**From:** Nicola Moore on behalf of Planning.Responses  
**Sent:** 24 July 2019 09:09  
**To:** Planning Scanning  
**Subject:** FW: WA/36/19/HH & WA/37/19/L

**WA/36/19/HH & WA/37/19/L**

Additional comments

Proposed First Floor Plan at 1:100 scale

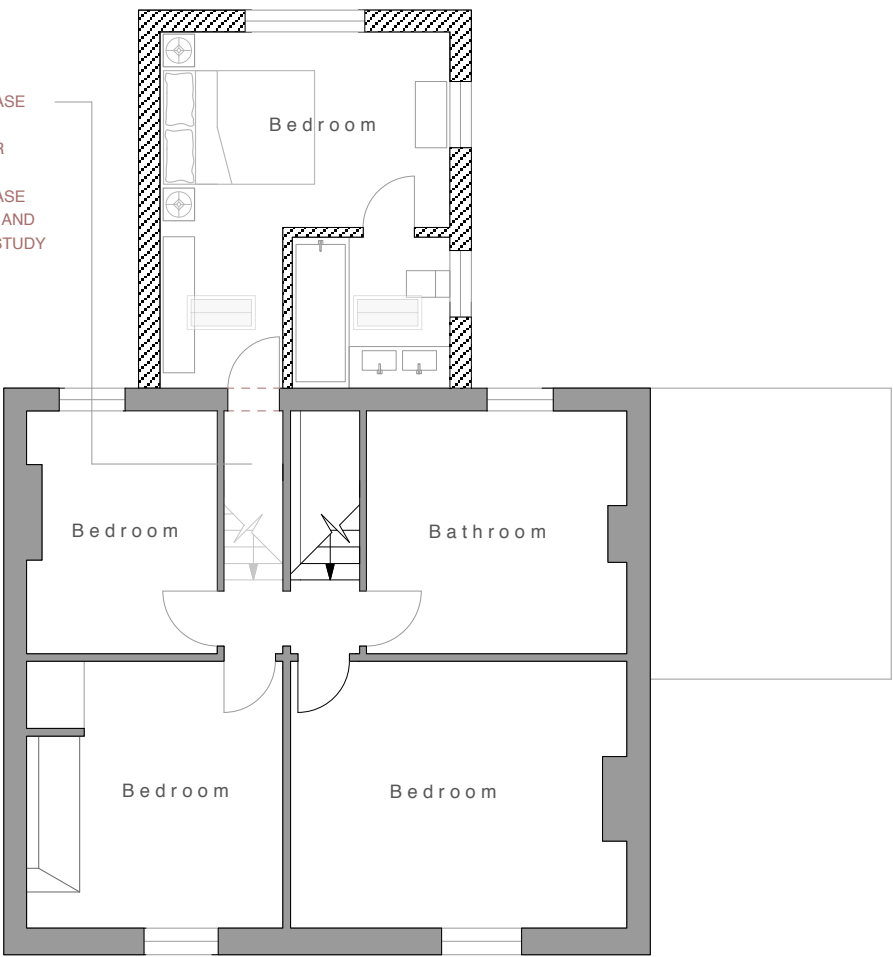
I also note that reference is now included that the stair case will be retained in-situ, but that flooring will be inserted at the top in order to provide level access to the extension. This will ensure that the stairs remain for future reference.

Whilst this element of the proposal is generally acceptable, more detailed information could be provided for by way of condition. This will indicate how the floor will be inserted without harming the surrounding historic fabric.

CLIENT	Mr & Mrs J Waights	SCALE	1:100 @ A3
SITE	Holly Tree Cottage, The Street, Walberton	STATUS	PL / LBC
PROJECT	Proposed First Floor Extension	AUTHOR	AH
DRAWING	002 Proposed Garage & Roof Plans	DATE	23 04 19

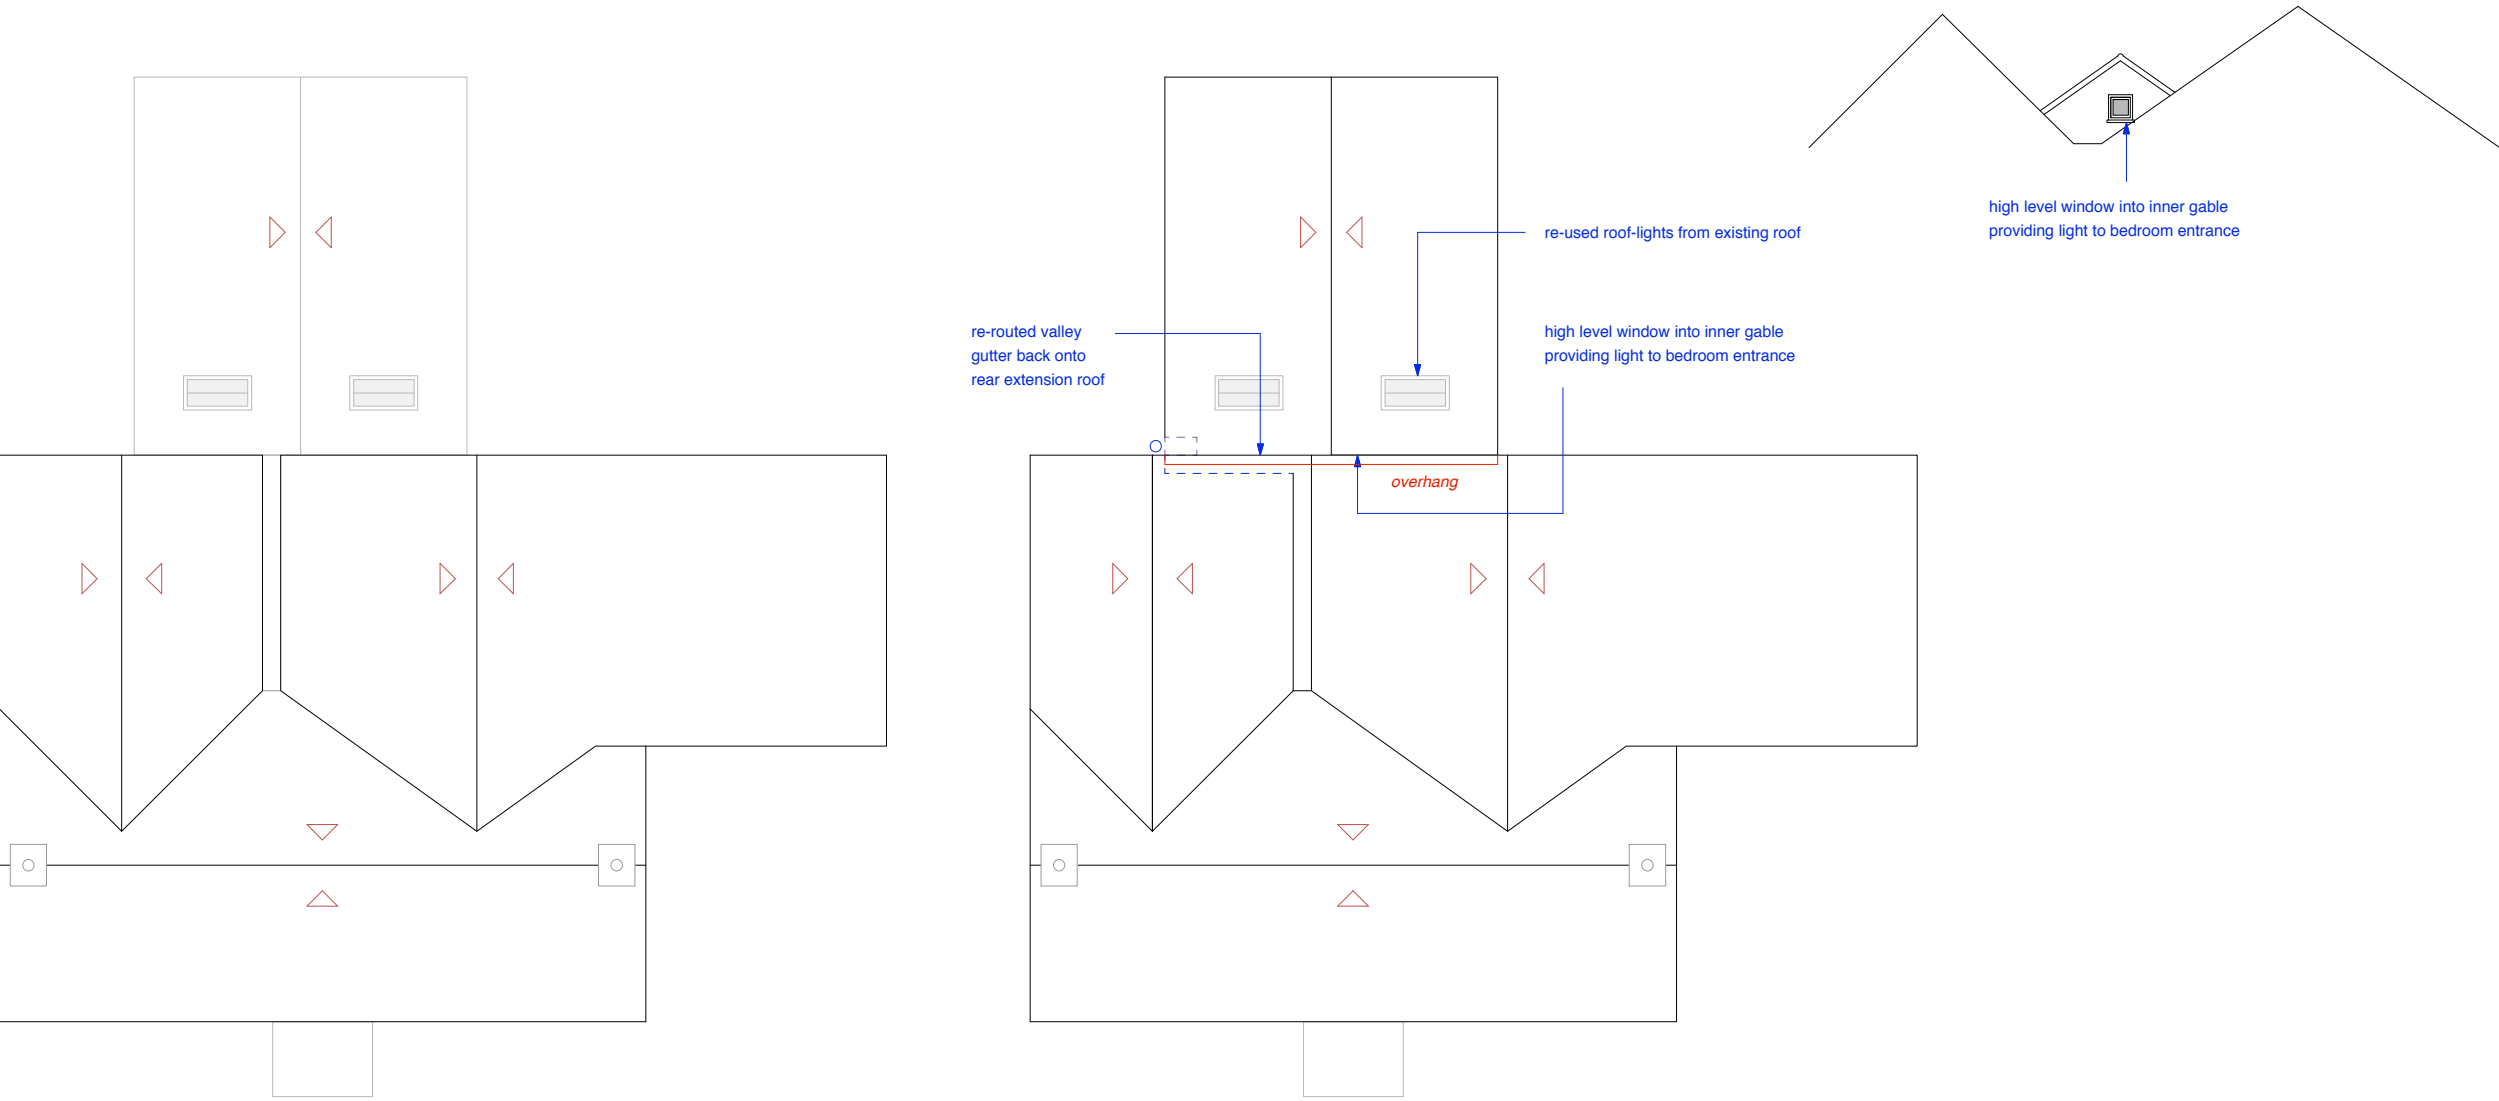
I note that revised plans have been submitted regarding this proposal. These revised plans remove the proposed garage/carport structure. Such an amendment is positive and reduces the harm to both the conservation area and the listed building.
